Revision 7, Bulletin 6

- A. The Construction Documents for the above referenced project are hereby revised as noted in Bulletin 6 for Hwy 24 & Brinkley Hill.
- B. This Bulletin supersedes and takes precedence over information provided prior to the date of this Bulletin.

SHEET NUMBER:  
**A101**

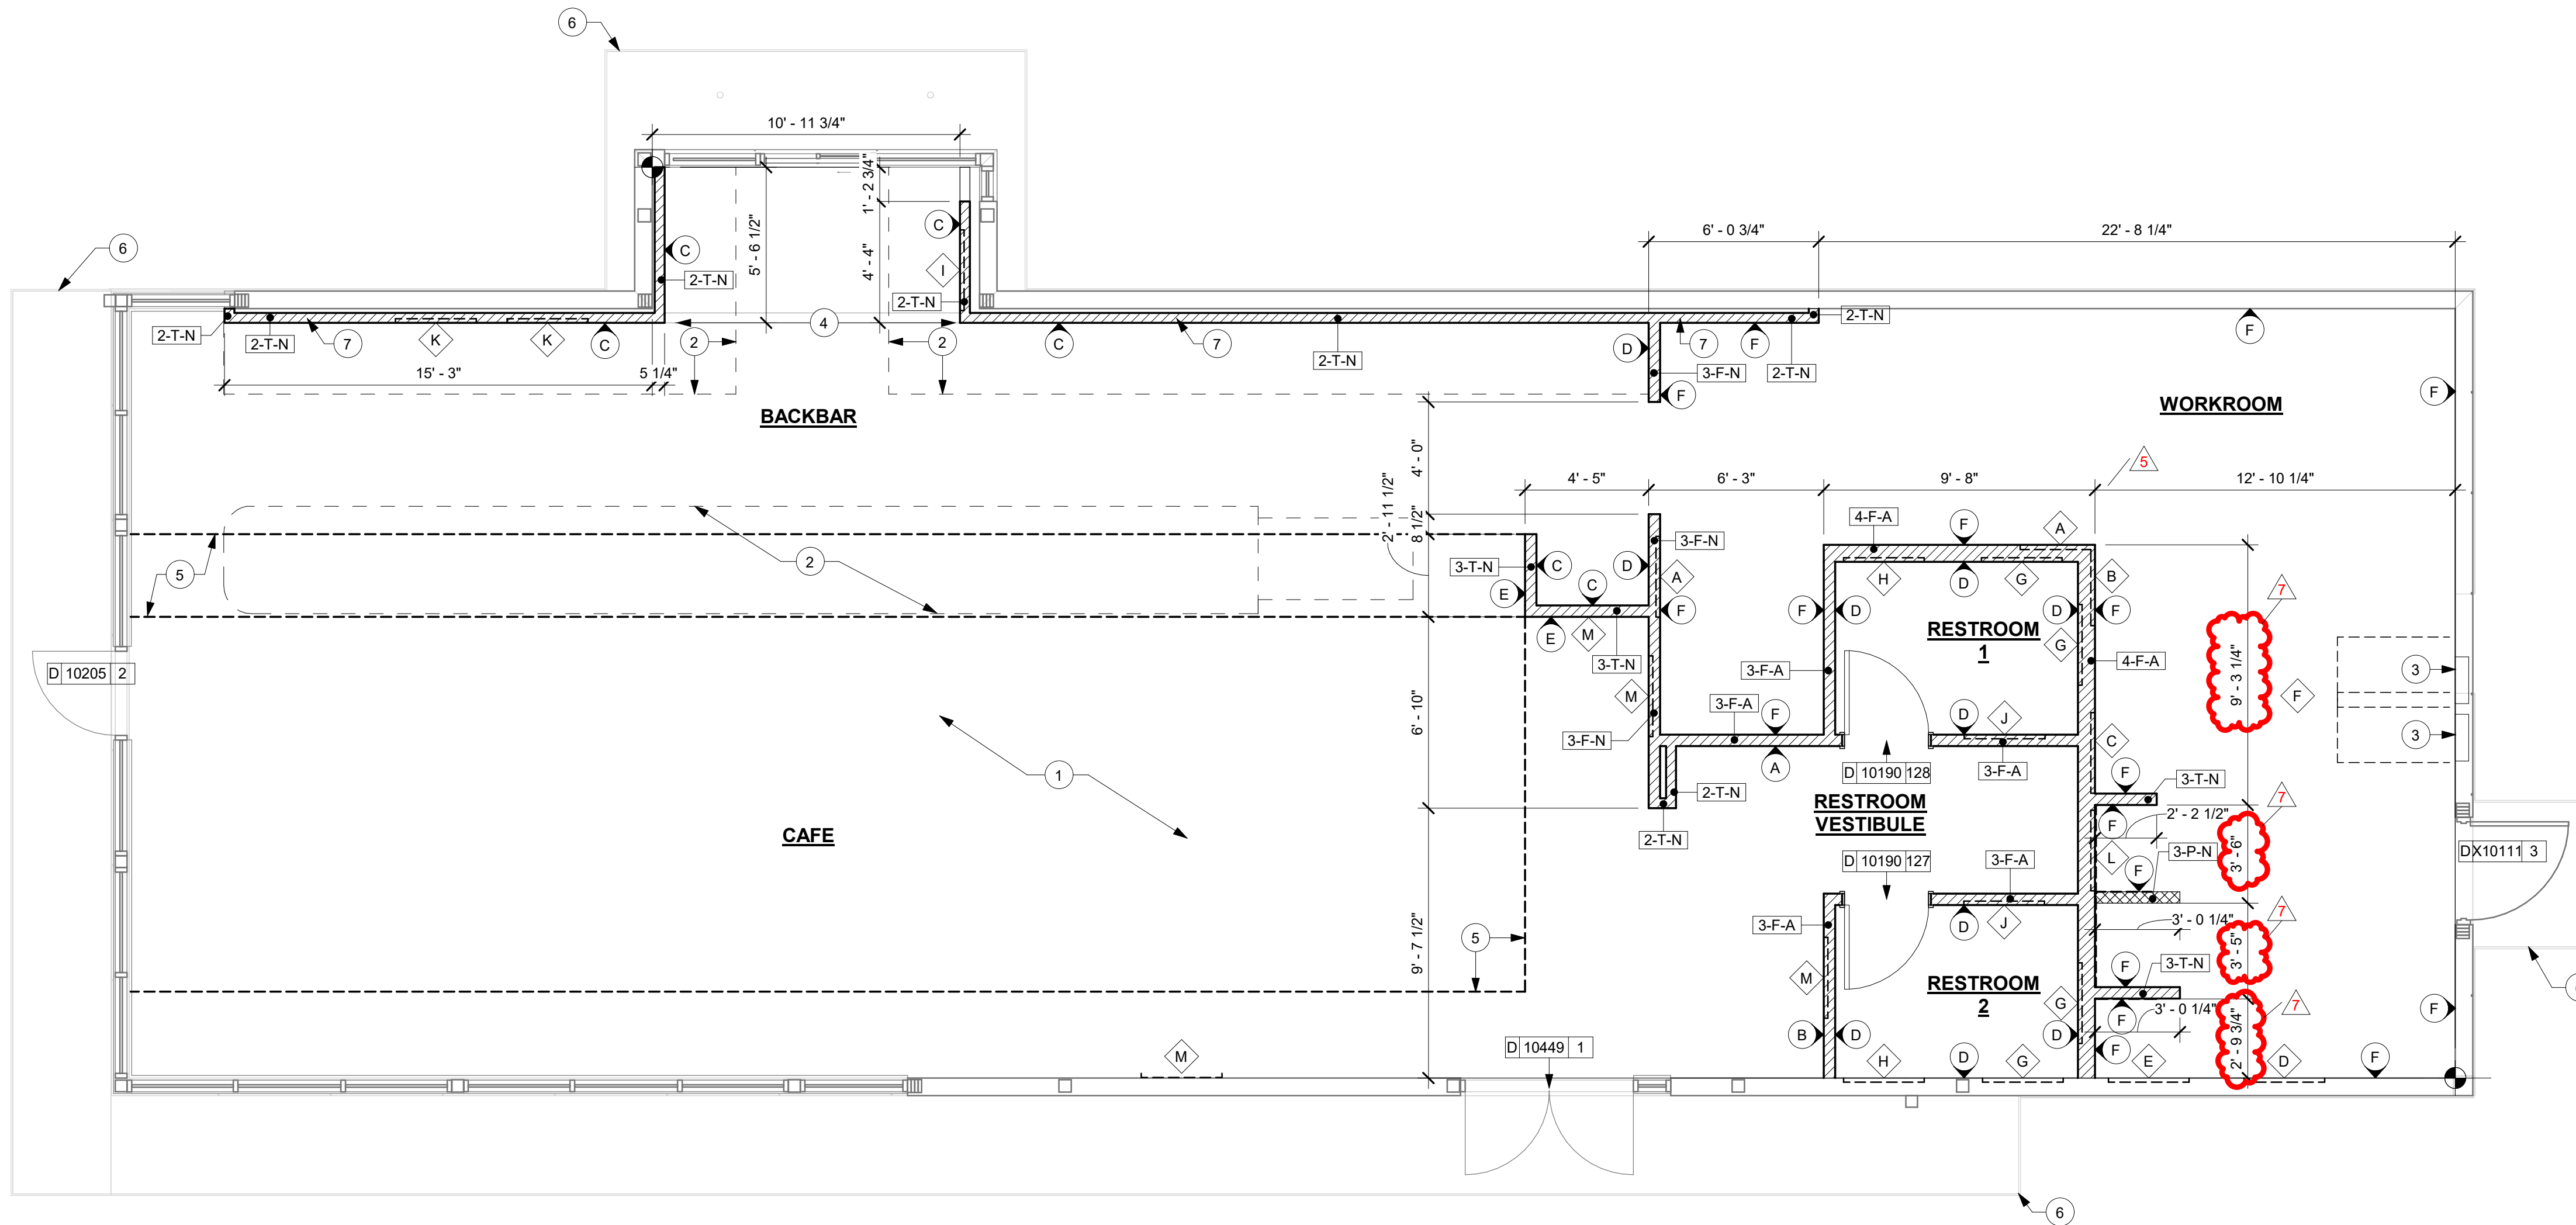
- 2. Sheet A101:
 - a) Revised floor plan to show three walls shifting in the Workroom area.
- 3. Sheet A102:
 - a) Revised dimensions on plan to show new locations of floor penetratons.
- 4. Sheet I101:
 - a) Revised plan to show new 3-comp sink and adjustments.
- 5. Sheet I203:
 - a) Elevations 2&5/I203: Revised the elevations to show the new 3-comp sink and dishwasher adjustment.

SHEET NUMBER: **E101**

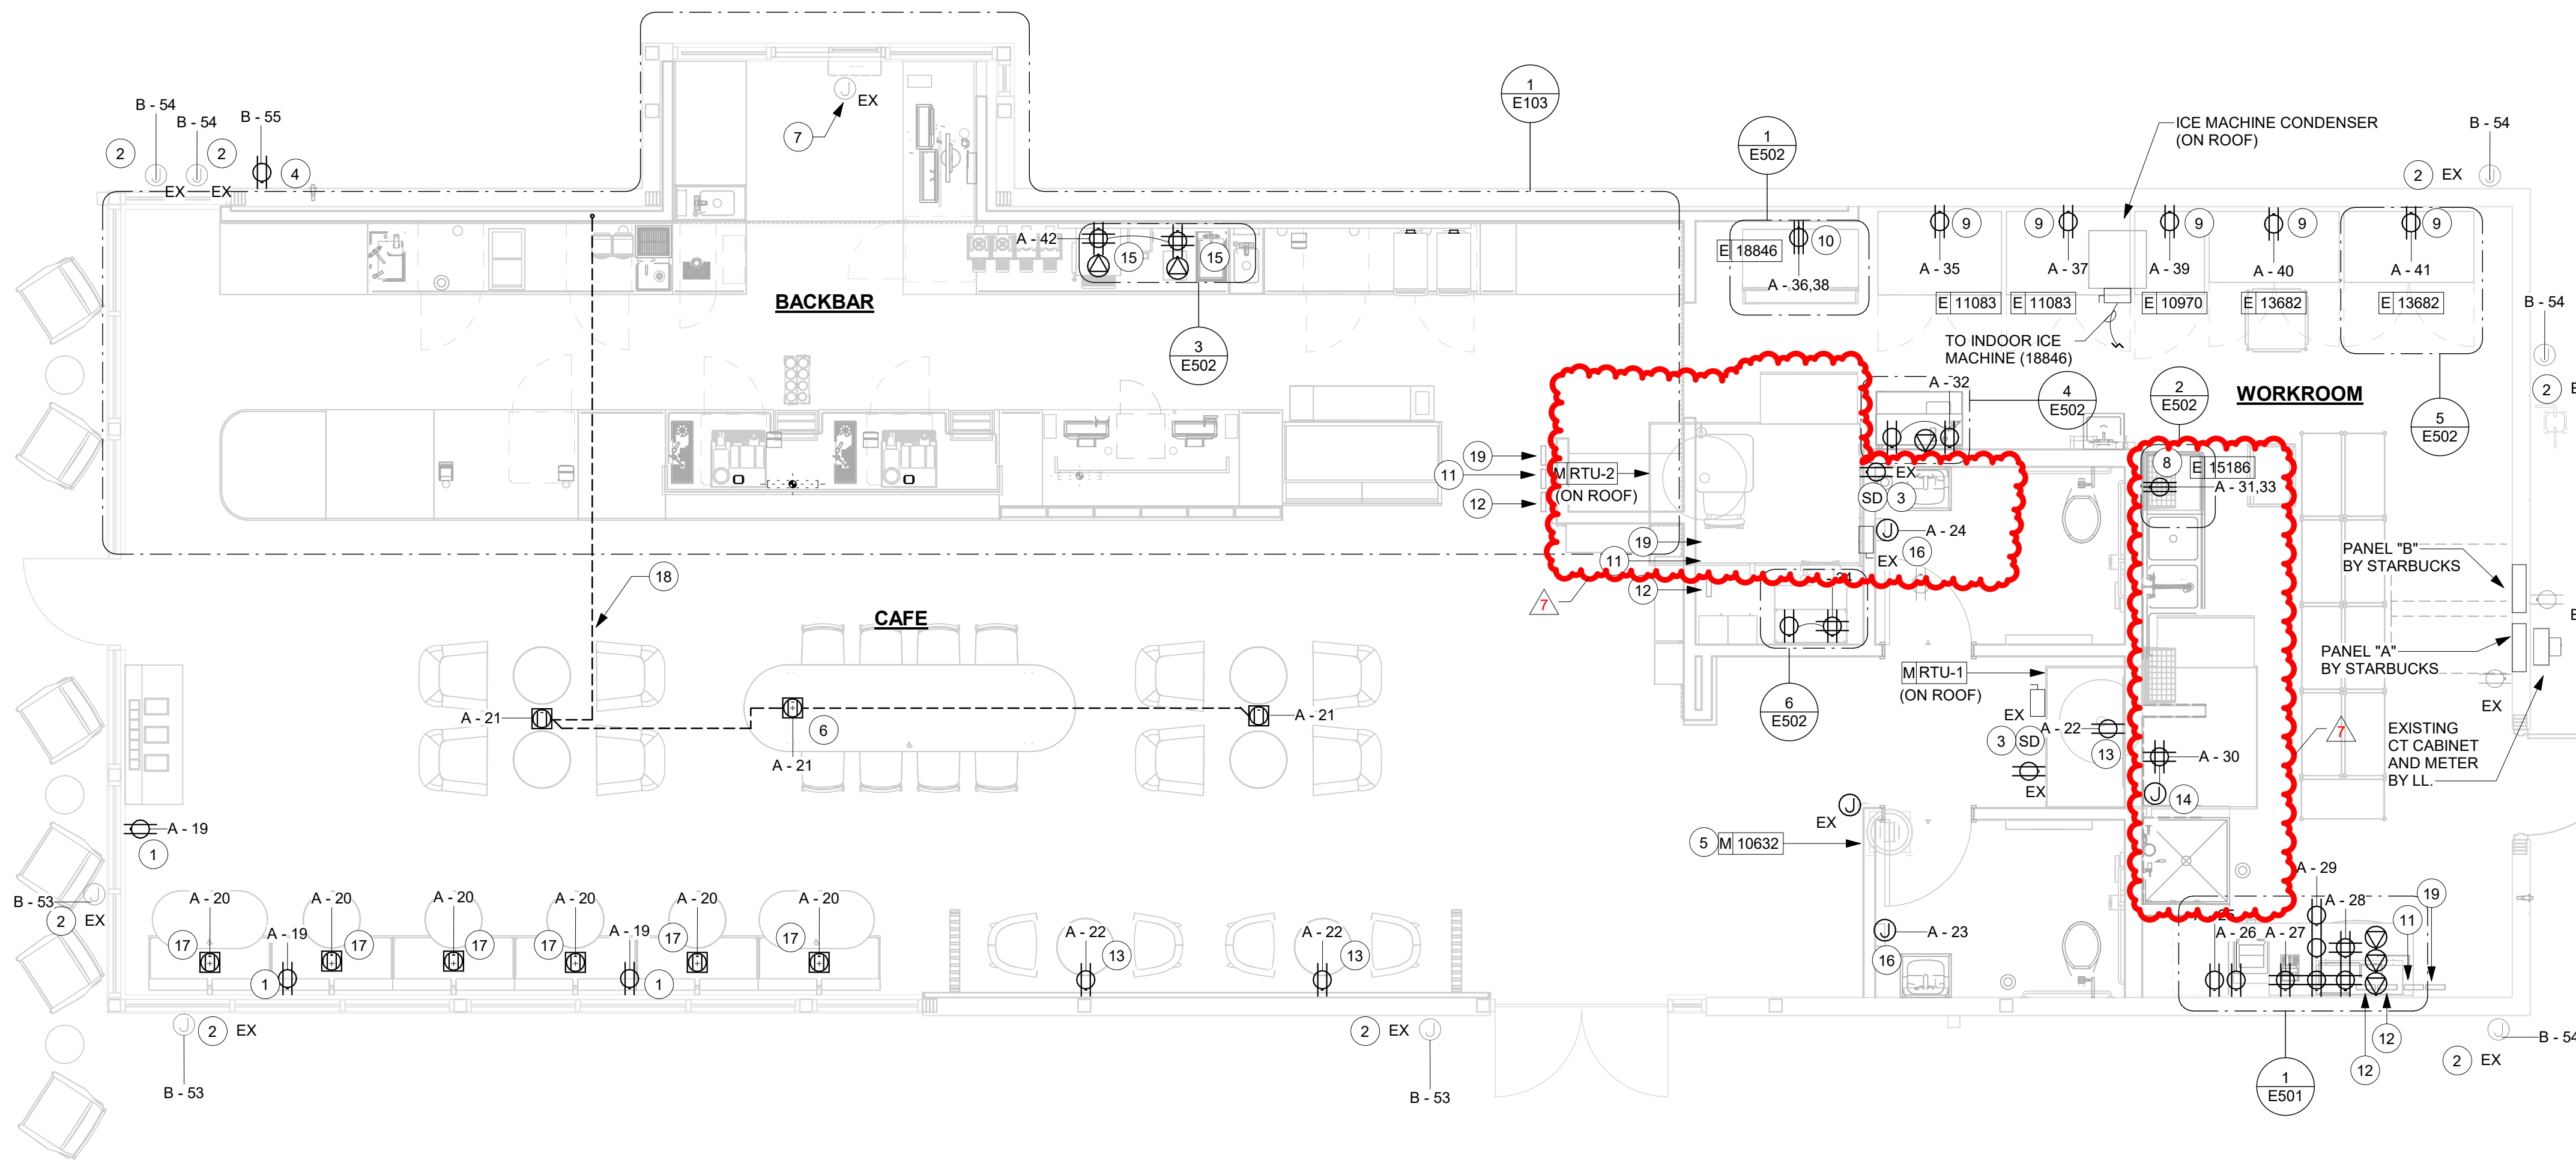
- 6. Sheet E101
 - a) Shifted receptacle and junction box to match revised compartment sink changes.
 - b) Visual changes for existing rooftopunit receptacle,disconnect switch and notes.

SHEET NUMBER:  
**P101**

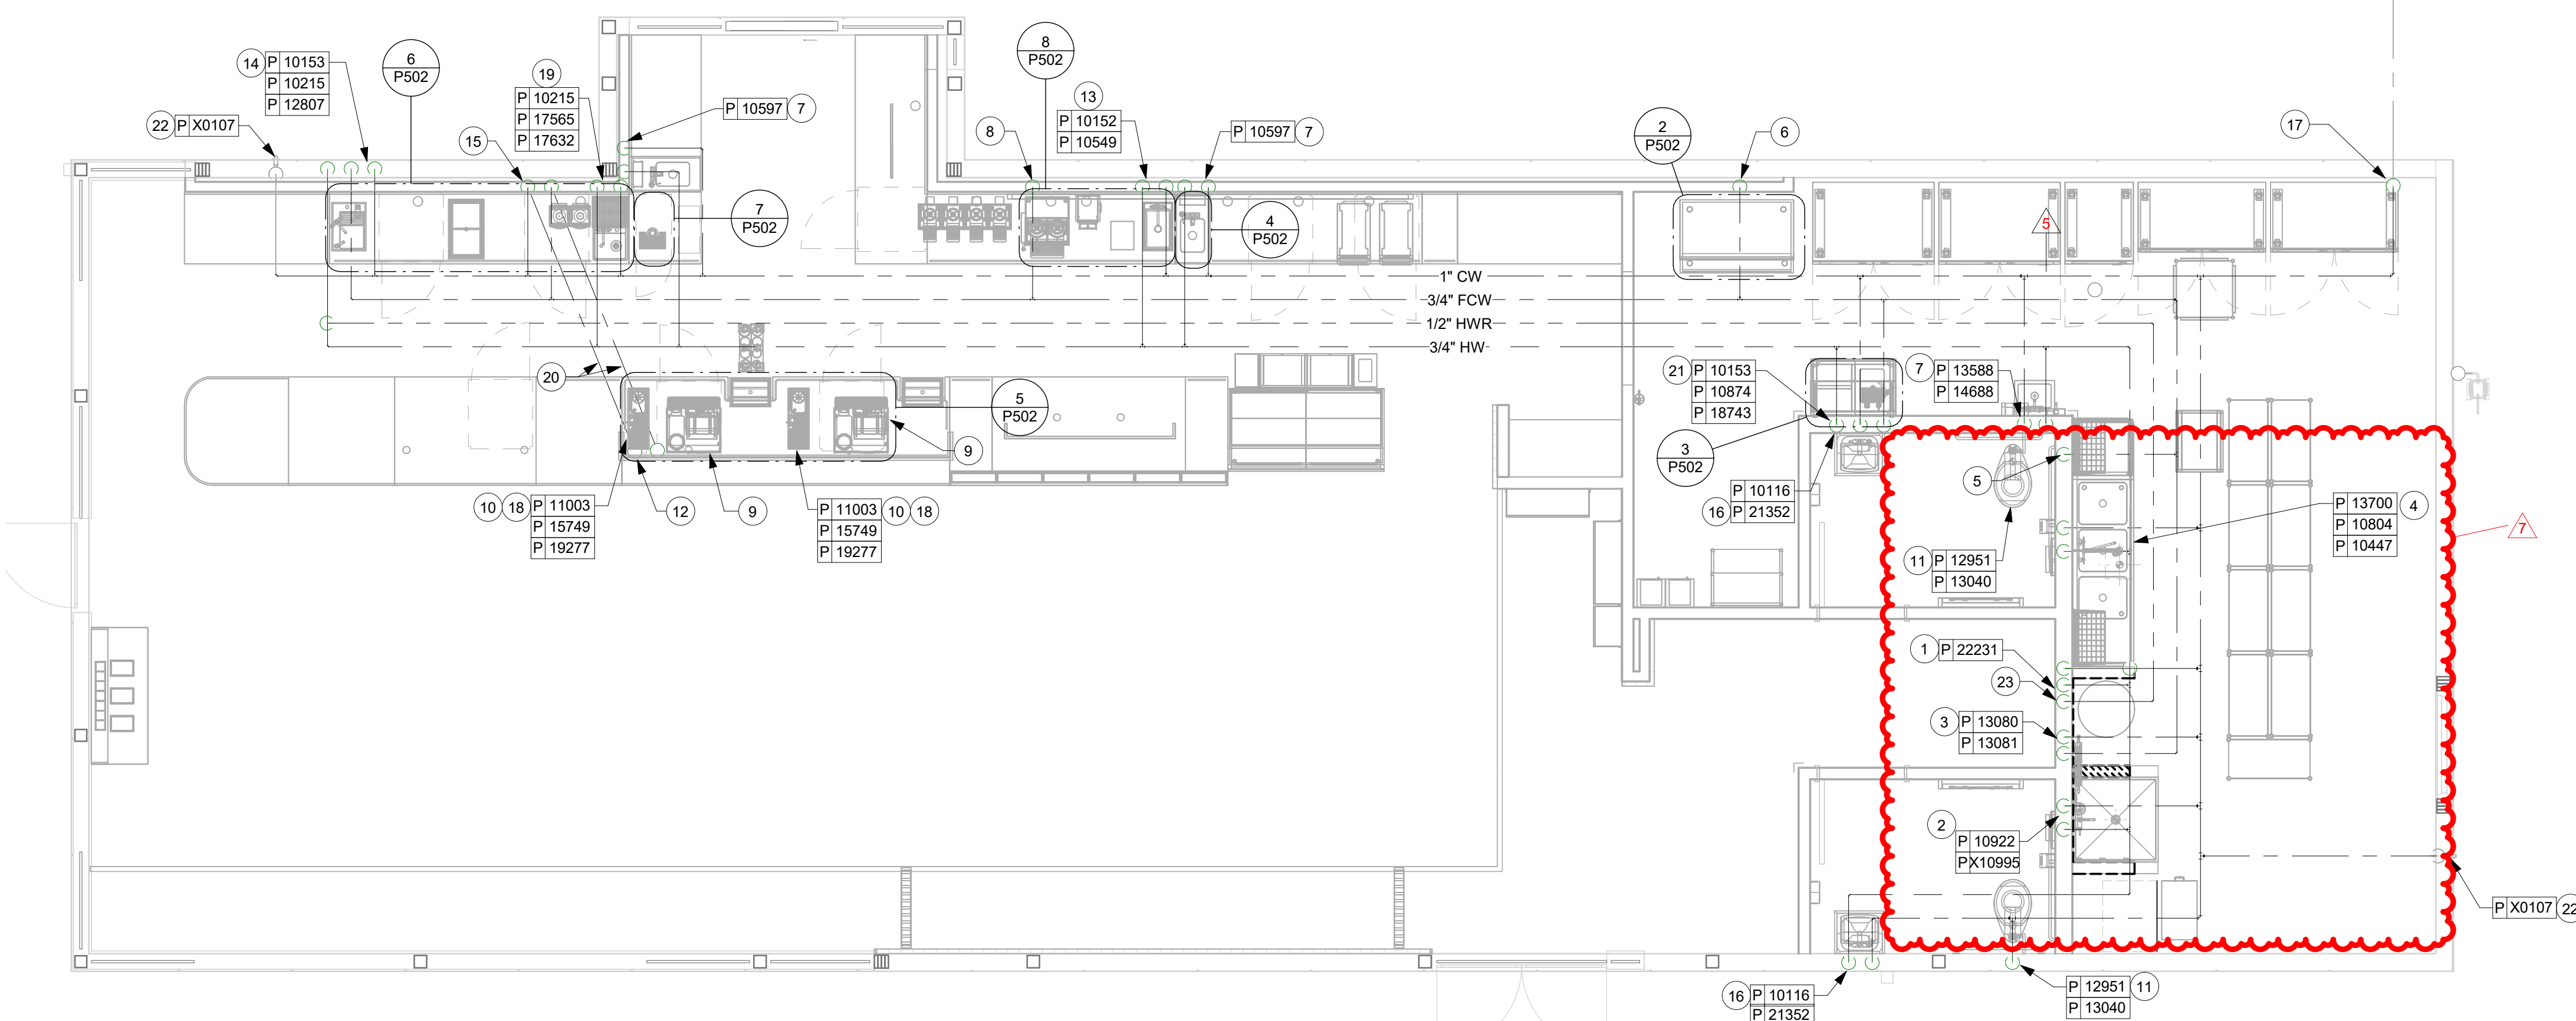
7. Sheet P101:
 - a) Shifted water lines to relate with the changing of 3 compartment sink.
8. Sheet P102:
 - a) Shifted floor sink related to 3 compartment sink
 - b) Moved floor drain for hot water heater and filters.
 - c) Moved drain for mop basin.
